Consultation Response from KC, Highways Development Management
2026/90868 Land north of, 39, Hightown Lane, Holmfirth, HD9 3HY
Erection of detached dwelling (part within a Conservation Area)
Date Responded: 6 May 2026
Responding Officer: Sheila Henley
Responding Ref: 3-46-97

Recommendation: No objection subject to planning conditions

Reference to Plans: Proposed Site and Block Layout OP-1300-PL-700-04; Proposed Floor Plans OP-1300-DR-200-01 and Proposed Elevations OP-1300-DR-200-02

Drawing Number
OP-I300-DR-200-01
 Drawing Title
Overview Plans

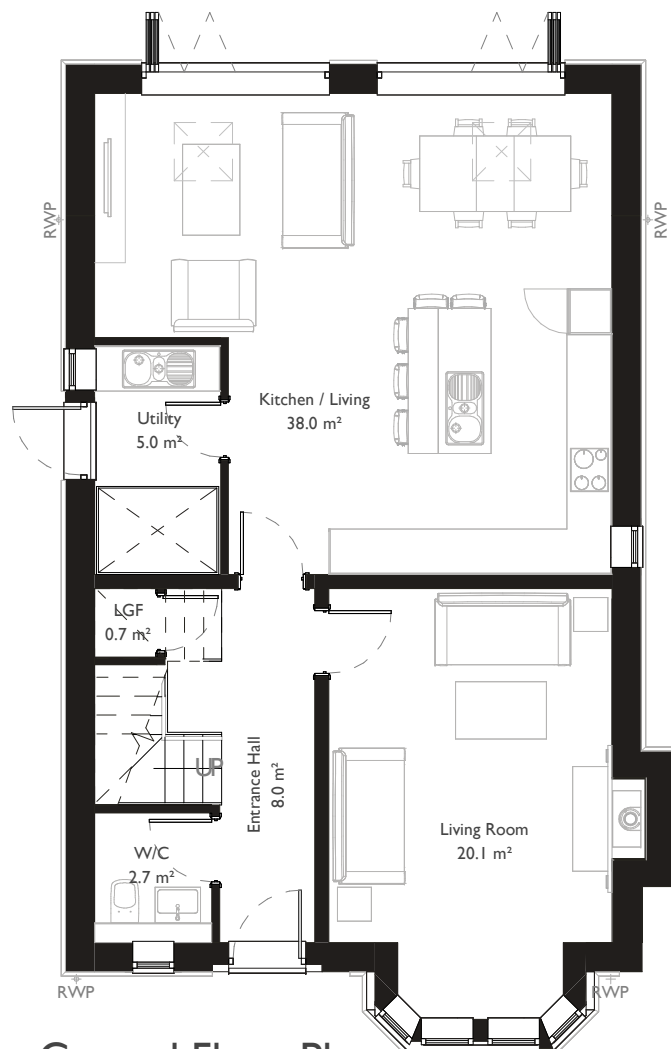
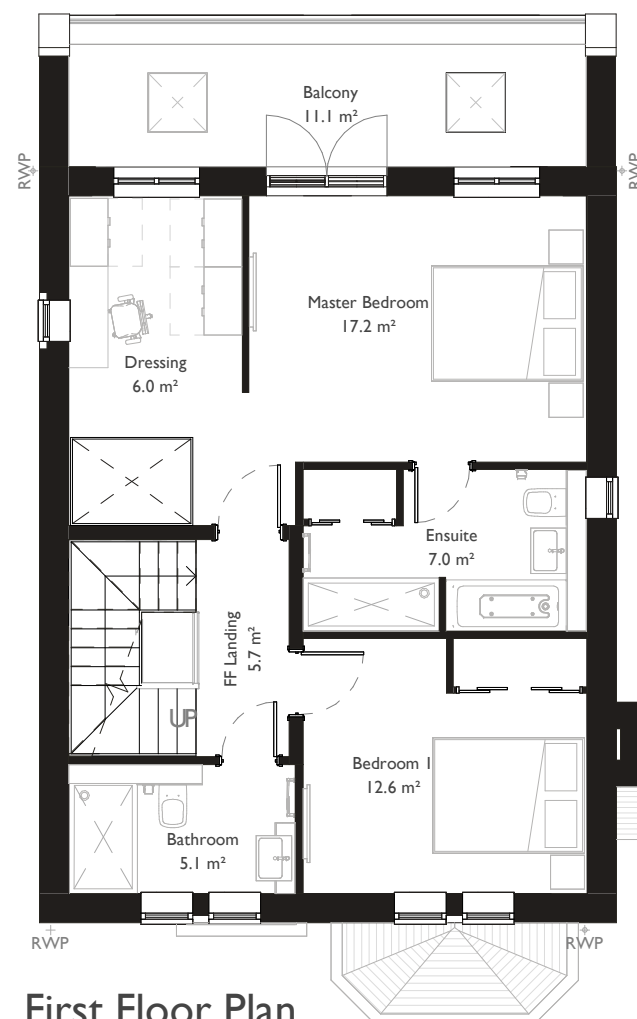
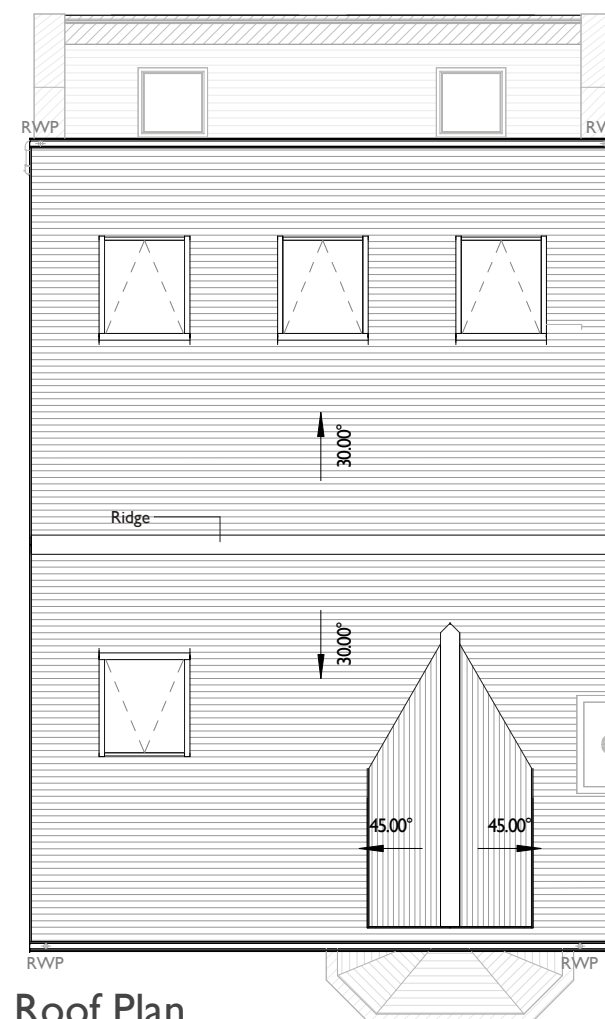
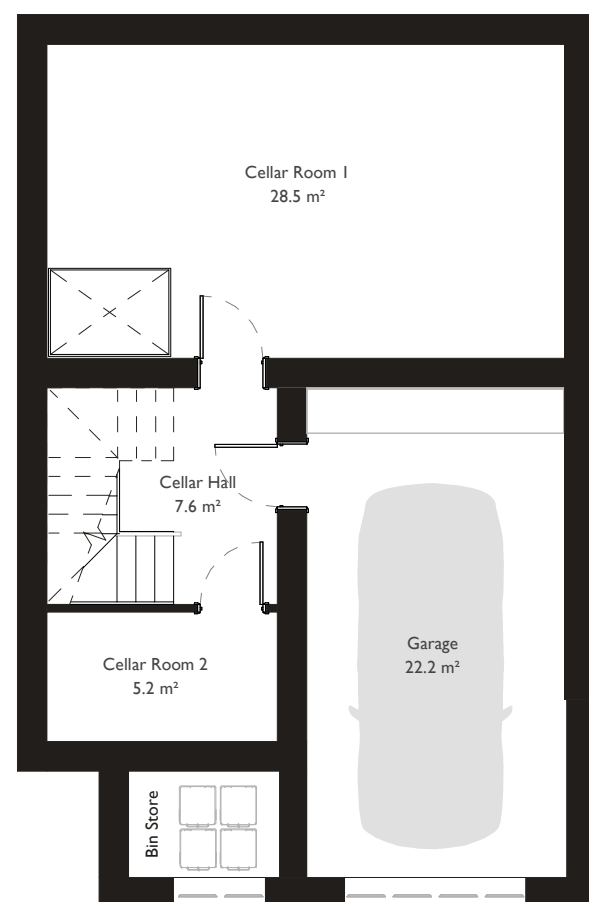
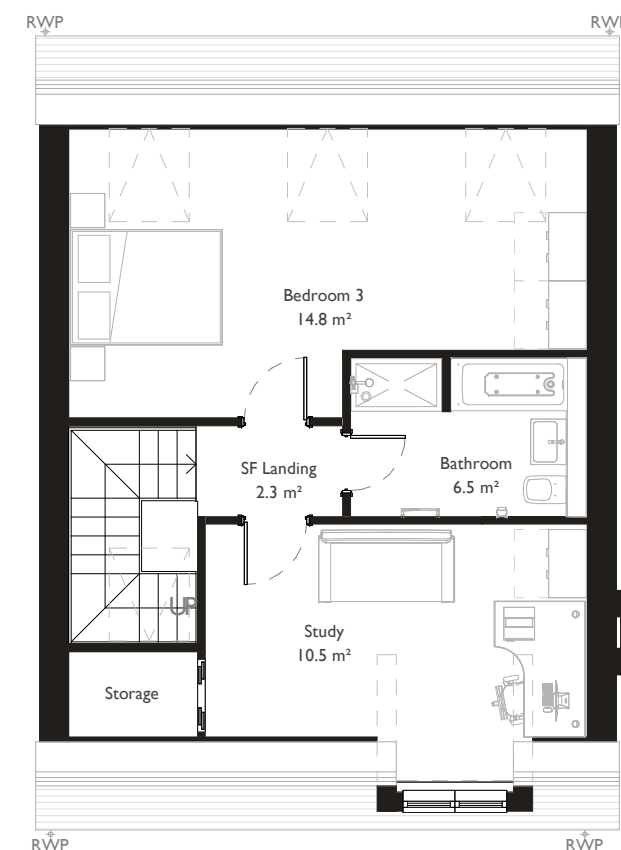
The proposed garage is of adequate internal size to meet the minimum 6 x 3m to allow accommodation of a car and storage of cycles and other items.

The intended two exterior driveway parking spaces are of adequate width, but shorter in length than recommended 5.0m where there is to be a retractable garage door. This means that there would be a slight overhang into paved area in advance of the driveway spaces. Given the circumstances at this location of a shared private street with on-street parking, it is unlikely to pose a significant hazard although it would be a betterment to push back the building to provide full clearance and alignment with the neighbouring plots.

The amount of car parking of three spaces exceeds the advice in the KHDG SPD of two spaces for three bedroomed units and would allow flexibility, such as for visitor provision on using the garage for car parking or sufficient hardstanding within the plot to meet guidance and Policy LP22.
